Rezoning Transportation Analysis

Petition Number: 2022-119

From: Jake Carpenter, PE

REZONING PETITION
FOR PUBLIC HEARING

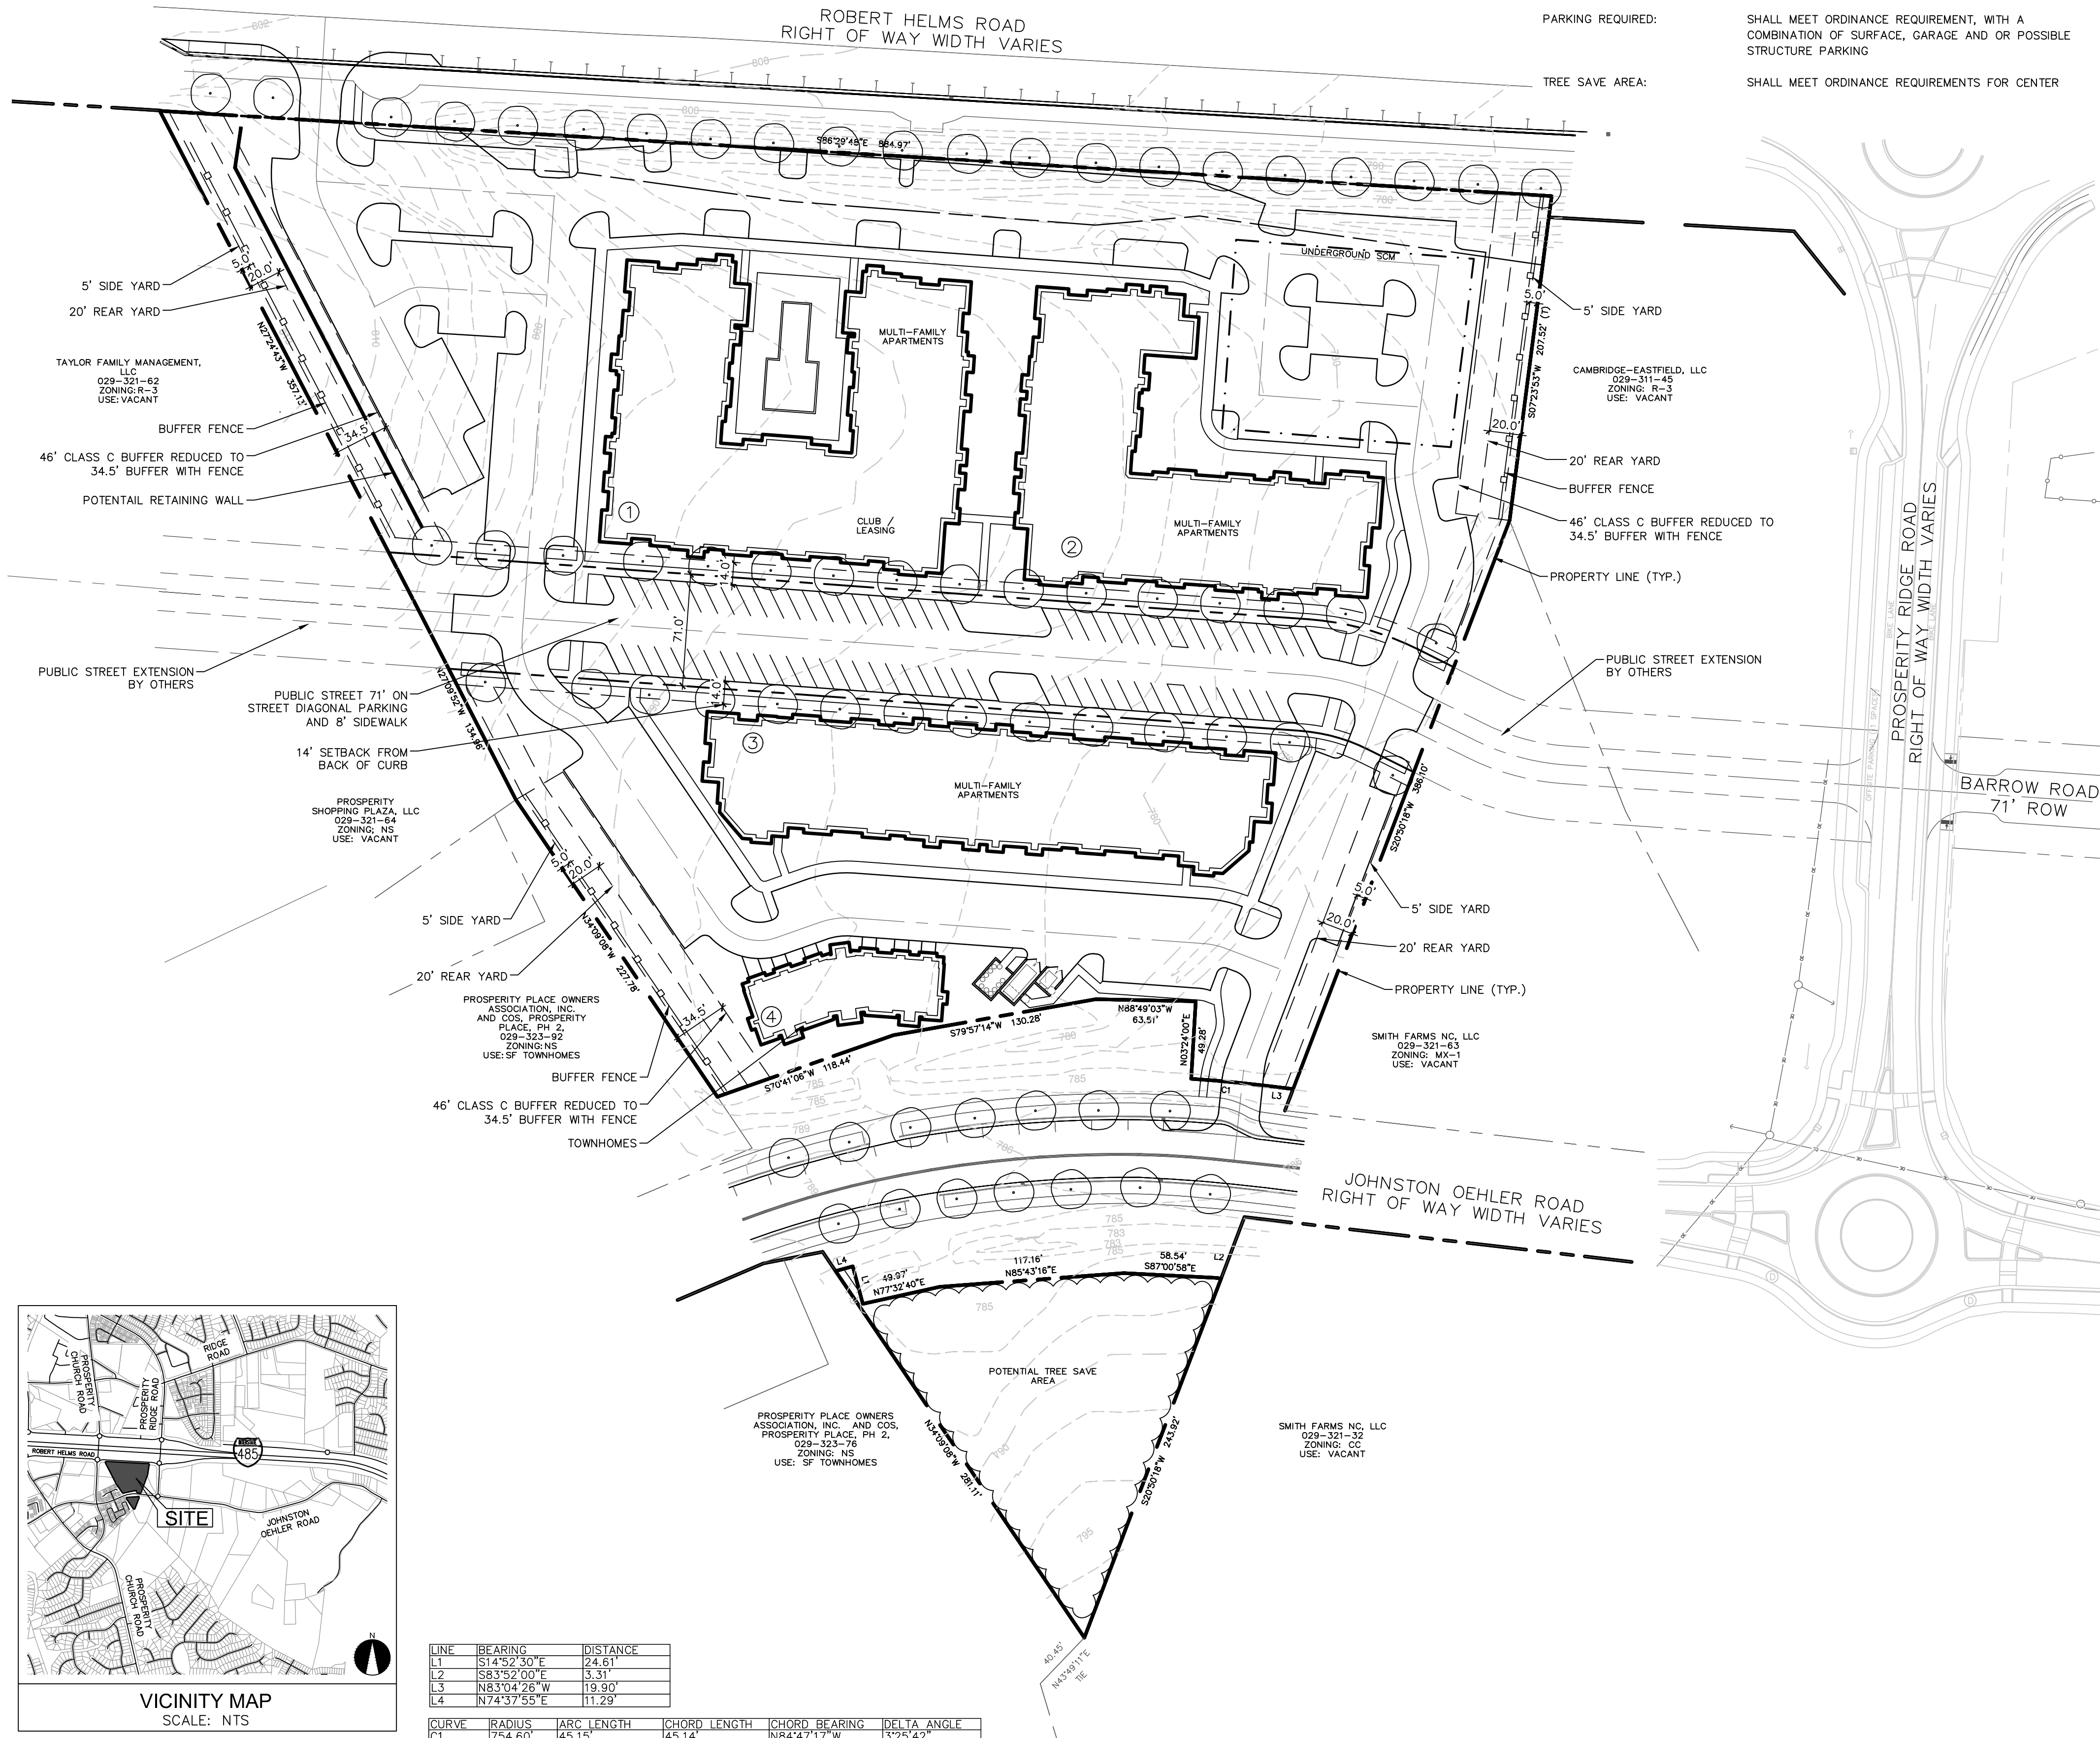
Label and dimension the curb and gutter from the centerline for each road on the site plan.

- Outstanding Comment form 12-29-22:** Revise site plan by dimensioning and labeling all ROW along Robert Helms Road and Johnston Oehler Road from the roadway centerline.
- ~~Revise site plan and conditional note(s) to commit to construct an 8-foot planting strip, and 8-foot sidewalk on the internal public roadway extension per Chapter 19. The site plan shall label and dimension both items from the back of curb and gutter or edge of pavement.~~
- ~~The proposed dwelling units exceeds 12 per acre. Per Chapter 20 Subdivision ordinance, revise site plan and conditional note(s) to commit to construct an 8-foot planting strip, and 8-foot sidewalk along the public roadway extension. The wider sidewalk also meets the Charlotte WALKS Policy.~~

8. **Outstanding Comment form 12-29-22:** Revise site plan and conditional note(s) to commit to existing on-street parking by adding an ADA stall to Johnston Oehler Road and Robert Helms Road.

9. **Outstanding Comment form 12-29-22:** Revise site plan and conditional note(s) to remove the site entrance on Robert Helms Road per NCDOT comments.

Clarifying Comment 02-22-23: Remove all references to a site entrance on Robert Helms Road.

10. **Outstanding Comment form 12-29-22:** Revise site plan and conditional note(s) to extend all public infrastructure along the public roadway extension to the property line.
11. **Outstanding Comment form 12-29-22:** Revise site plan and conditional note(s) to callout the roadway extension roadway cross section per CLDSM.
12. **Outstanding Comment form 12-29-22:** Revise site plan and conditional note(s) by revising on-street parking space along the proposed public roadway extension to be installed as parallel parking stalls. One stall shall be an ADA compliant stall. **Note:** the proposed internal public road extension cannot be accepted for City maintenance until it is connected to the public roadway system by another public street connection.

Clarifying Comment 02-22-23: Remove all mention of diagonal parking spaces

13. **Clarifying Comment 02-22-23:** Revise site plan and conditional note(s) by adding a conditional note and callout to the site plan committing to coordination with CIP project Craven Thomas Road/Robert Helms Road Streetscape (Prosperity Village CNIP).
